# CITY OF ALBUQUERQUE

July 8, 2020

**Re: Dunkin Brands**  
**4201 Wyoming Blvd NE**  
**Traffic Circulation Layout**  
Architect's Stamp 07-06-2020 (G19-D042)

**2 ONE WAY DETAIL**  
3/4" = 1'-0" NOTE:

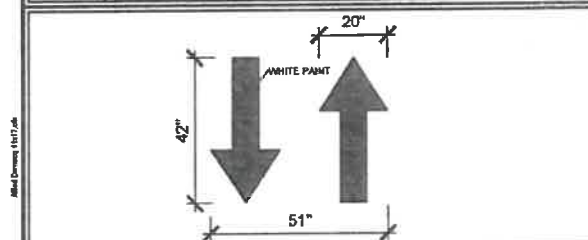
21. All one-way drives shall have "One Way" and "Do Not Enter" signage and pavement markings. Please show detail and location of posted signs and striping. Provide detail for pavement markings and signage. The signage must be located within private property not on COA property(Keyed note 18).

**8 BIKE RACK**  
N.T.S. NOTE:

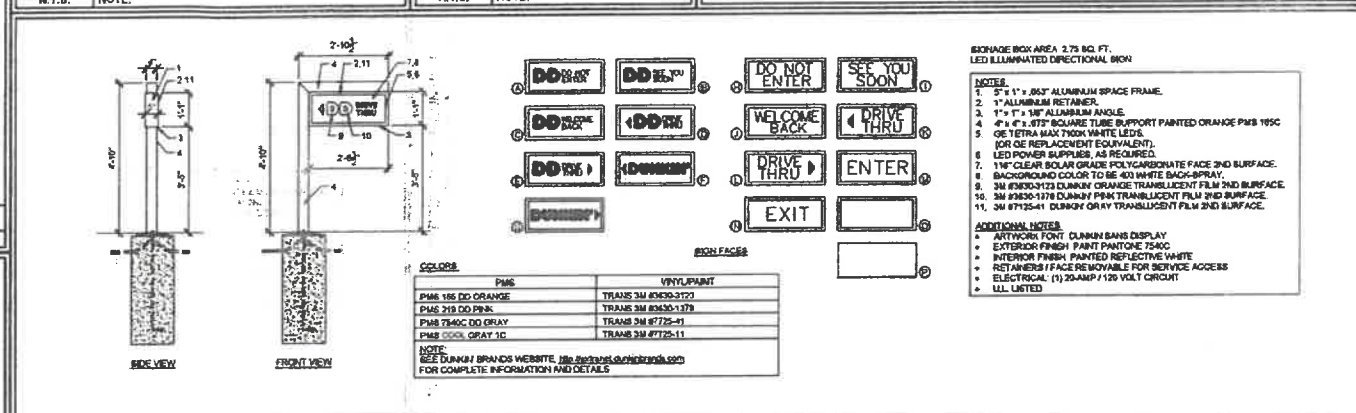
8. Motorcycle parking space: Label pavement MC
9. All bicycle racks shall be designed according to the following guidelines (IF APPLICABLE OR NOT INCLUDED IN YOUR NOTES OR DESIGN):

- a. The rack shall be a minimum 30 inches tall and 18 inches wide.
  - b. The bicycle frame shall be supported horizontally at two or more places. Comb/toaster racks are not allowed.

- c. The rack shall be designed to support the bicycle in an upright position. See the IDO for additional information.
  - d. The rack allows varying bicycle frame sizes and styles to be attached.

- e. The user is not required to lift the bicycle onto the bicycle rack.
  - f. Each bicycle parking space is accessible without moving another bicycle.

10. Bicycle racks shall be sturdy and anchored to a concrete pad.
11. A 1-foot clear zone around the bicycle parking stall shall be provided.
12. Bicycle parking spaces shall be at least 6 feet long and 2 feet wide.

TCL-1.0

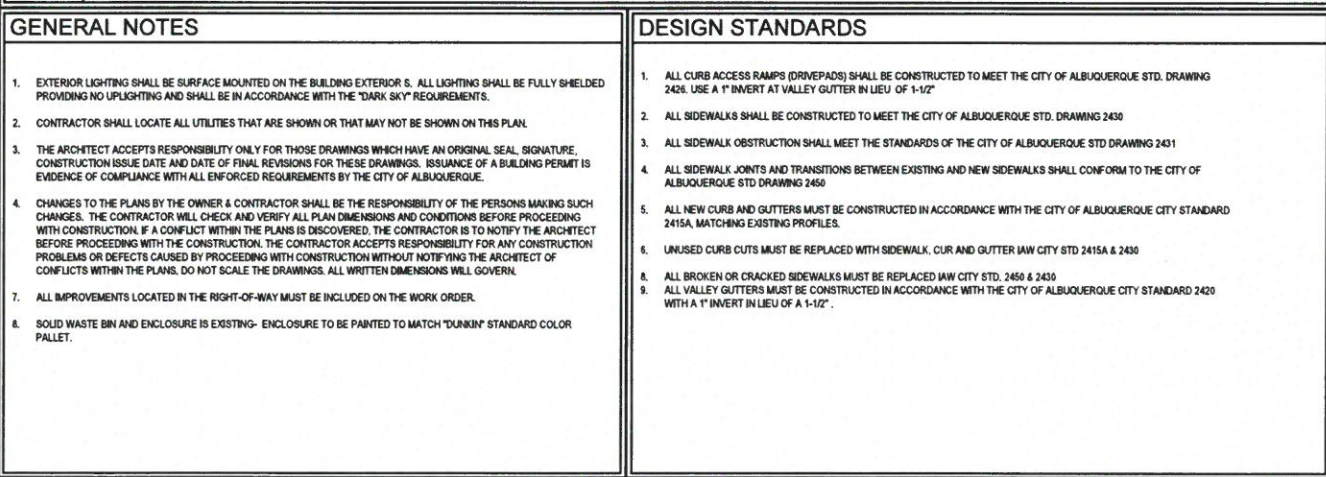
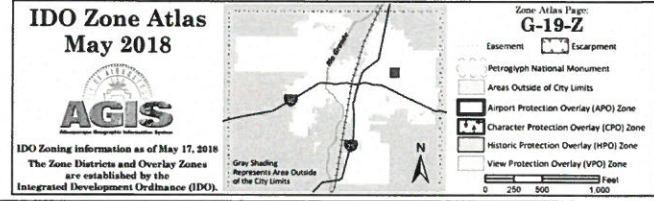
1. List the number of parking spaces required by the zoning code as well as the proposed number of parking spaces including bicycle and motorcycle parking. Coordinate these calculations with Zoning.
2. Identify the right of way width, medians, curb cuts, and street widths on Wyoming Blvd and La Mirada Place.
3. You have too many driveways/pad off La Mirada Place. Suggest closing the nearest driveway to Wyoming Blvd.
4. Please list the width and length for all existing and proposed parking spaces. Some dimensions are not shown.
5. The minimum parking stall dimensions are:

6. The ADA accessible parking sign must have the required language per 66-7-352.4C NMSA 1978 **"Violators Are Subject to a Fine and/or Towing."** Please call out detail and location of signs.
7. ADA curb ramps must be updated to current standards and have truncated domes installed at the corner of La Mirada Place and Wyoming.

13. Show all drive aisle widths and radii. Some dimensions are not shown.
14. List radii for all curves shown; for passenger vehicles. Radius for delivery trucks, fire trucks, etc. is 25 ft. or larger.

15. Per the IDO, a 6 ft. wide ADA accessible pedestrian pathway is required from the public sidewalk to the building entrances. Please clearly show this pathway and provide details. **Where is this connection from Wyoming? Explain?**

16. Per DPM, a 6 ft. wide ADA accessible pedestrian pathway is required from the ADA parking stall access aisles to the building entrances. Please clearly show this pathway and provide details. The 6 ft width includes the ADA ramp.

17. All sidewalks along streets needs to be dimensioned (width).
18. Parking areas shall have barriers to prevent vehicles from extending over drive thru lanes.

19. Provide a copy of refuse approval for design and location.
20. You have one way pavement markings leading to two traffic pavement markings. This will be confusing to public usage. Please clear up this concern.

23. The minimum drive through lane width is **12 feet** with a 25 foot minimum radius (inside edge) for all turns. (A 15 foot radius can be used with an increase in lane width to 14 feet). Please dimension all lane widths and radii.
24. All the existing driveways/pad don't provide ADA access across the entrance/exist width, especially Wyoming. Please explain what are the intents for not providing ADA access route especially on Wyoming Blvd.
